**Application by Associated British Ports for the Immingham Green Energy Terminal  
The Examining Authority's written questions and requests for information (WQ2)  
Issued on Friday 17 May 2024**

**Responses are due by Deadline 4: Tuesday 4 June 2024.**

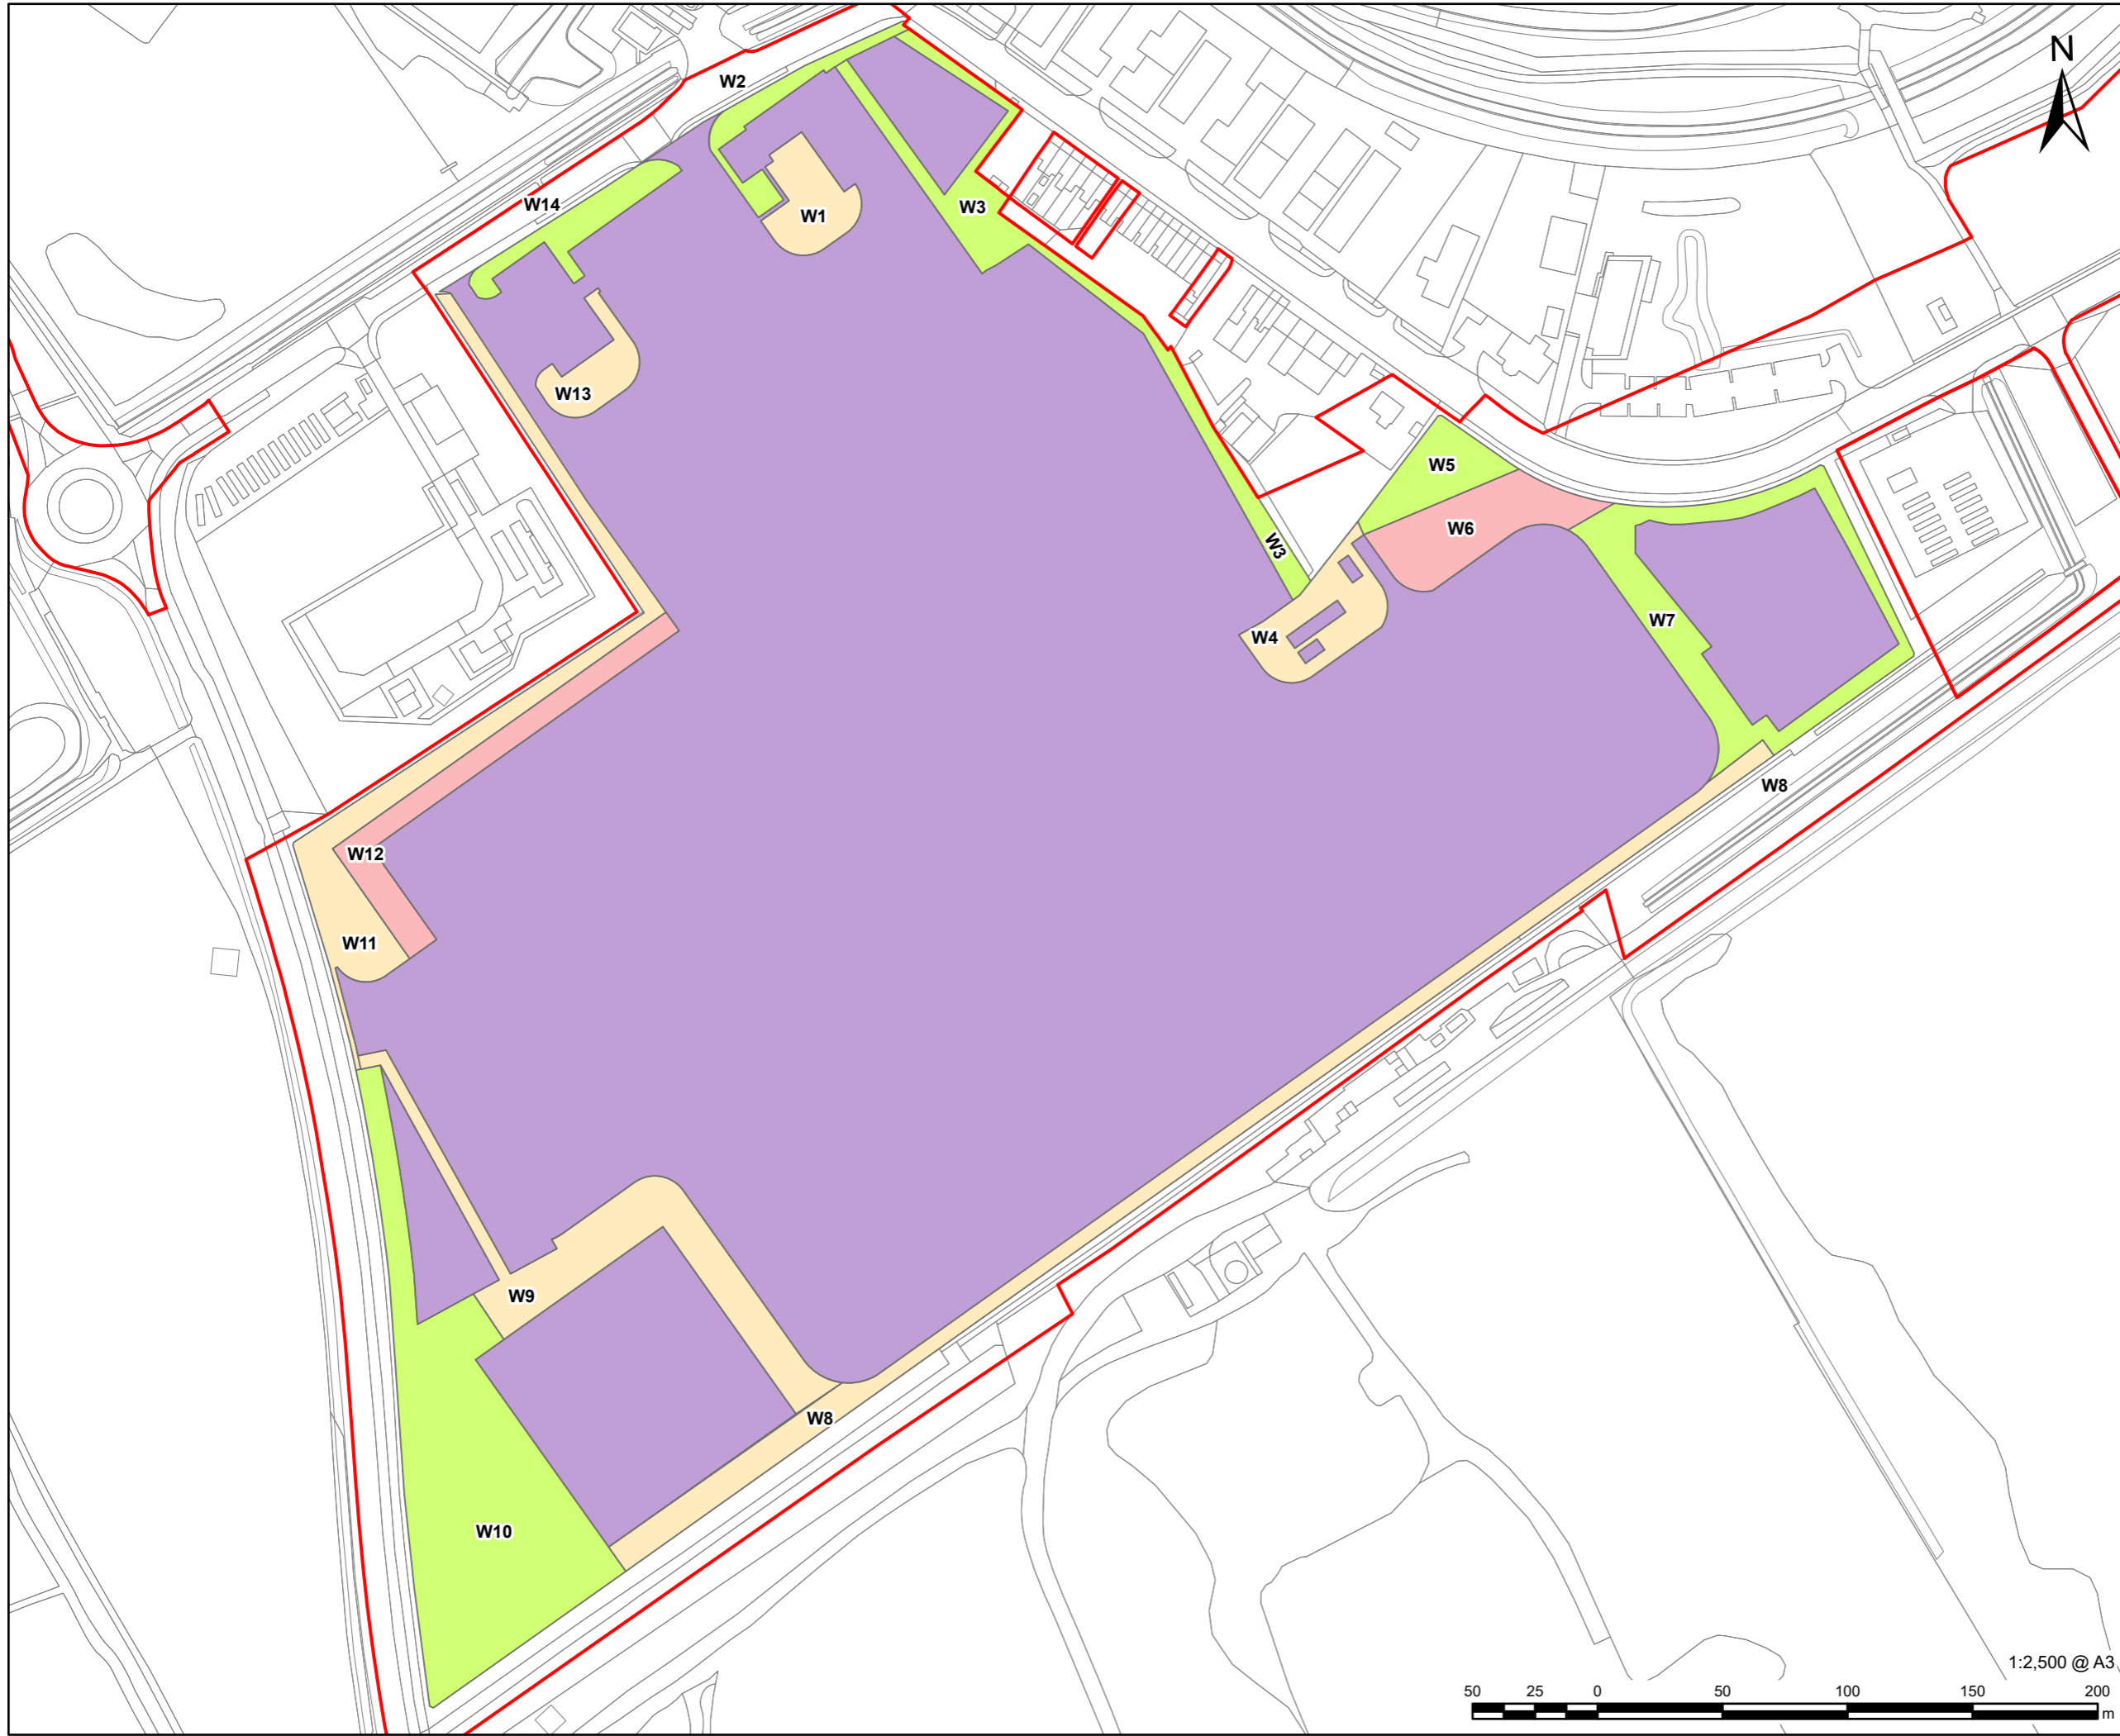
LV 2.3	The Applicant	<p><b>Outline Landscape and Ecological Management Plan</b></p> <p>On sheet 2 of the Indicative Landscape and Biodiversity Plan [APP-225], there is an uncoloured area directly south west of the rear of the Queens Road properties. During the ASI [REP2-023] the ExA were able to view this area and it appeared to be an integral part of the West Site, with no restrictions on inclusion into the Biodiversity Improvement Zone.</p> <ul style="list-style-type: none"> <li>• Indicate the proposed Biodiversity Zoning for this area.</li> <li>• If this is not proposed to be “green” (un-restricted, other than the 2m security zone either side of the fence), explain why.</li> </ul>
LV 2.4	The Applicant North East Lincolnshire Council	<p><b>Land directly to the northwest of 1 Queens Road</b></p> <p>During the ASI [REP2-023] the ExA were able to view this area from the West Site. It is noted that this area is outside the Order Limits, but due to the mature tree cover, it makes a positive contribution to the appearance of the area that helps to screen existing development and would also be beneficial in screening proposed development.</p>
